Planning Application No: 3/2024/0720

Proposal: Proposed conversion of existing agricultural building to dwelling and new domestic curtilage.

Location: Pinfold Farm Preston Road Ribchester PR3 3YD

Proposed Site Plan
Scale (1:200)

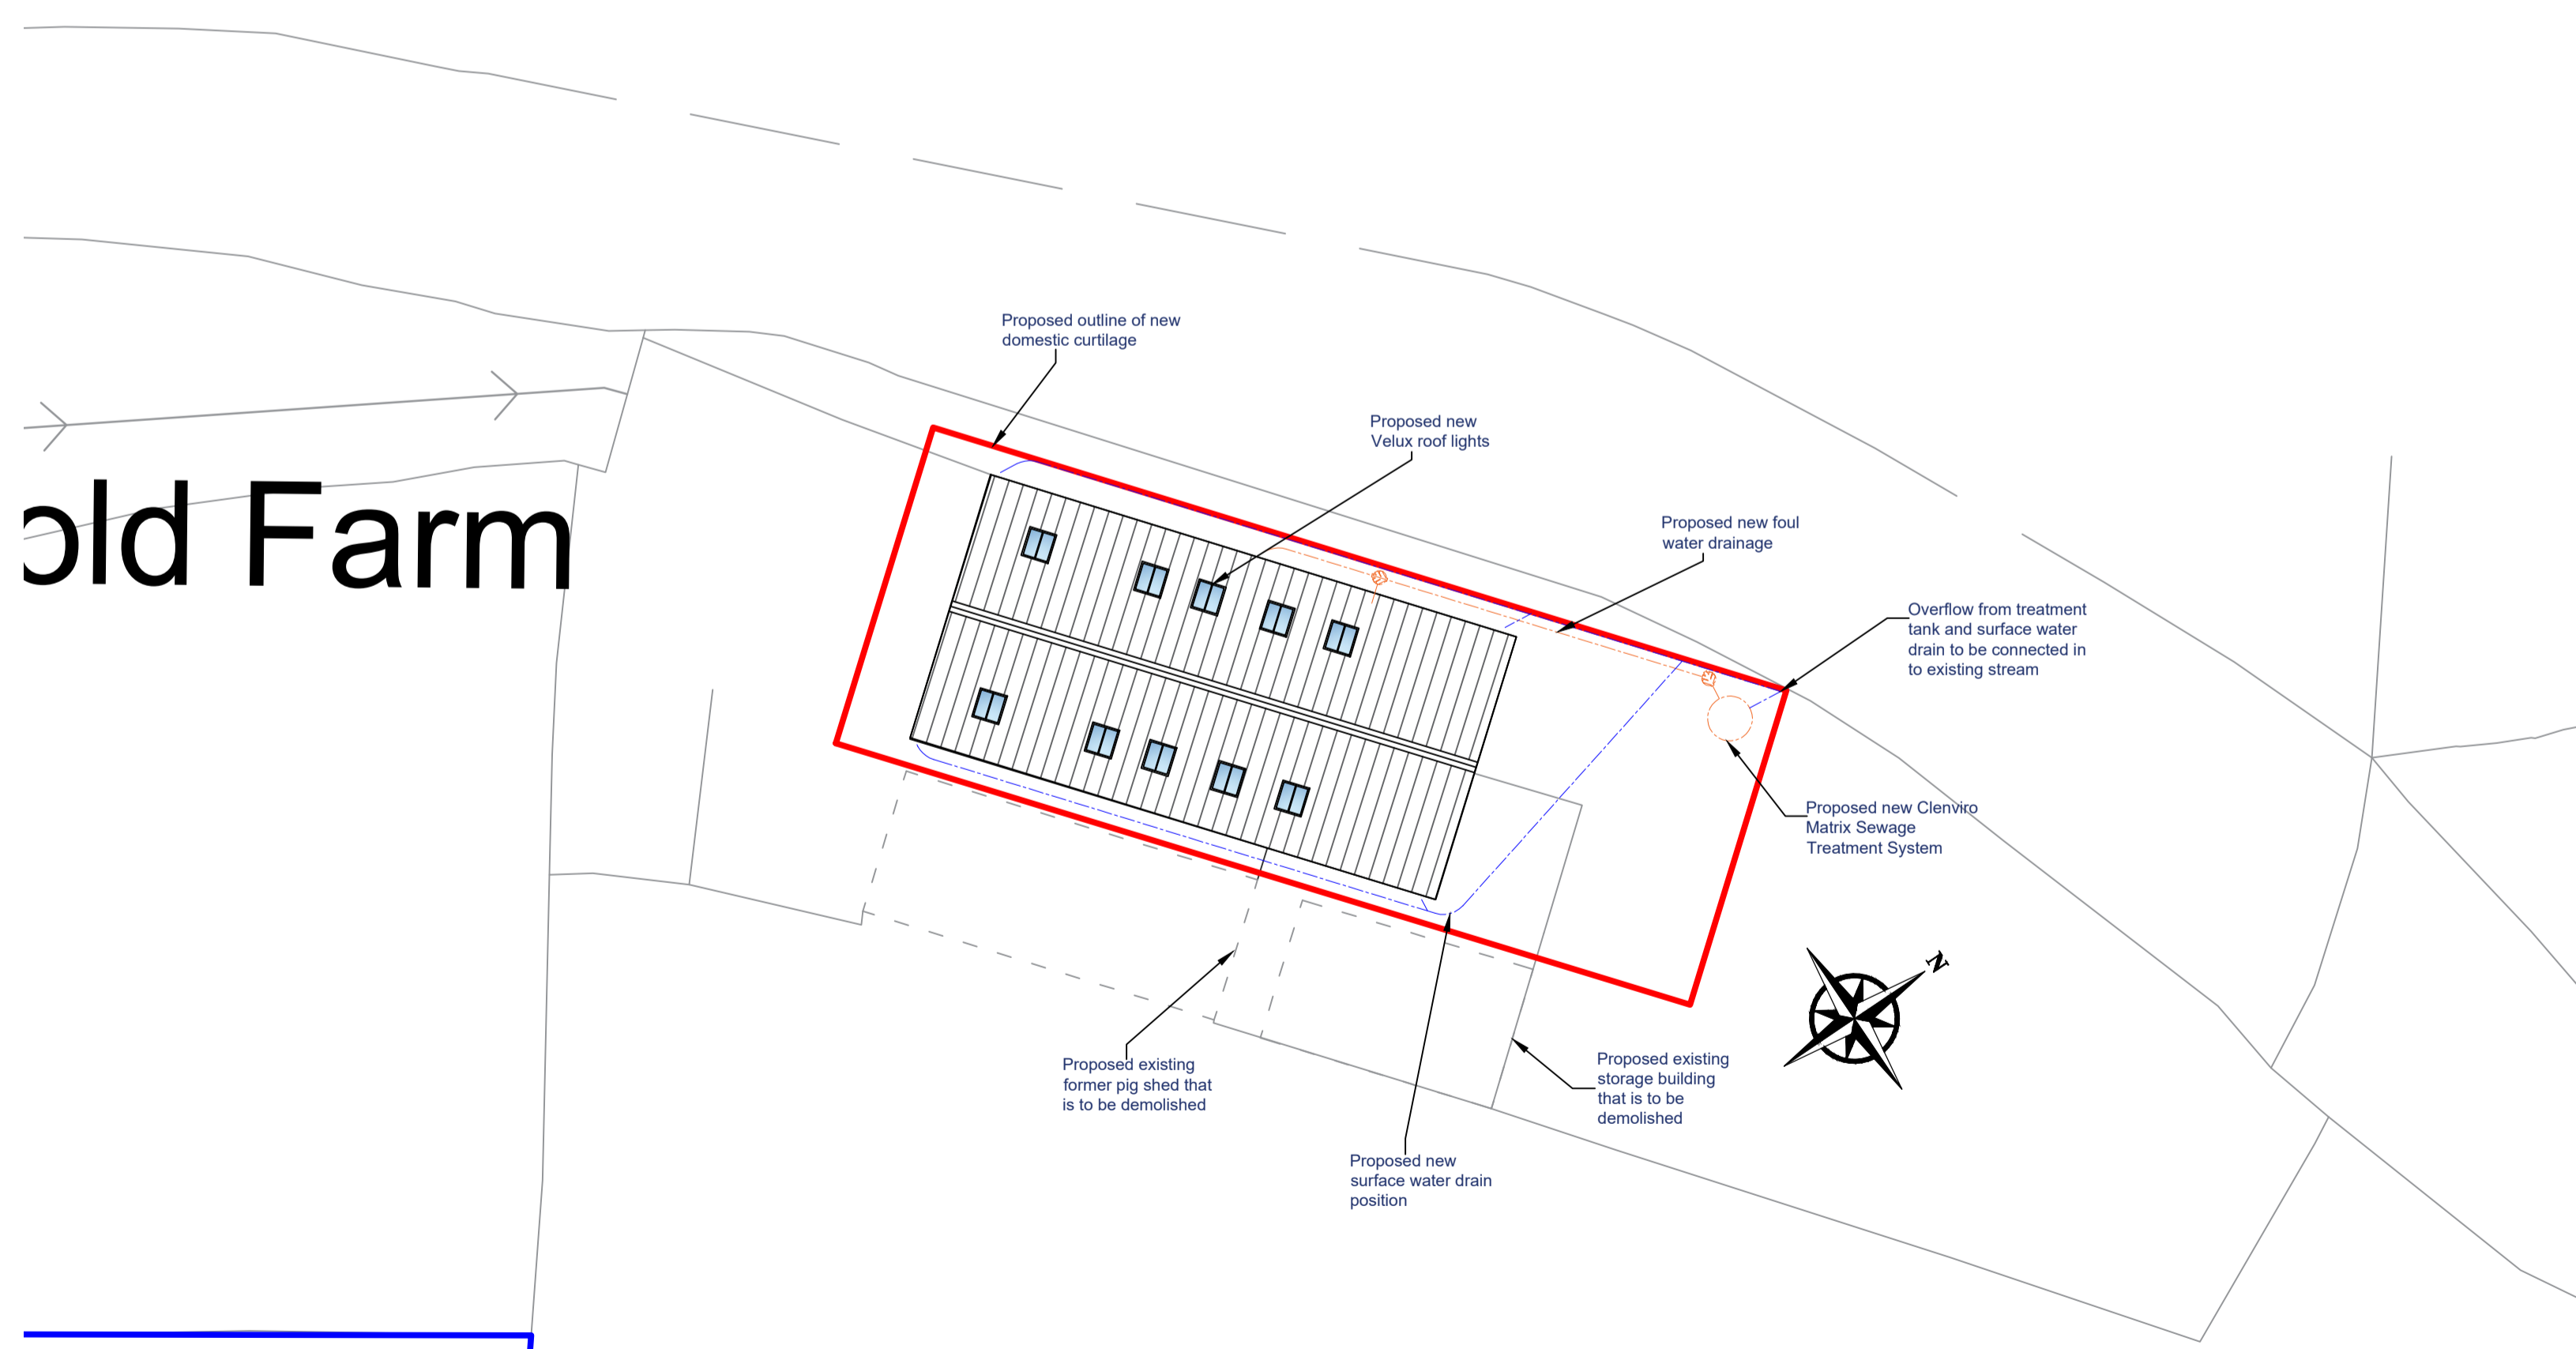
A parking plan is requested to show 3 parking spaces required by parking standards can be achieved within the curtilage of this proposed 4 bedroom property. No parking plan has been provided.

Only 2 parking spaces are being proposed. Parking standards require 3 parking spaces for this size of proposal.

There is no objection to the proposal on highway grounds providing the required parking spaces can be achieved.
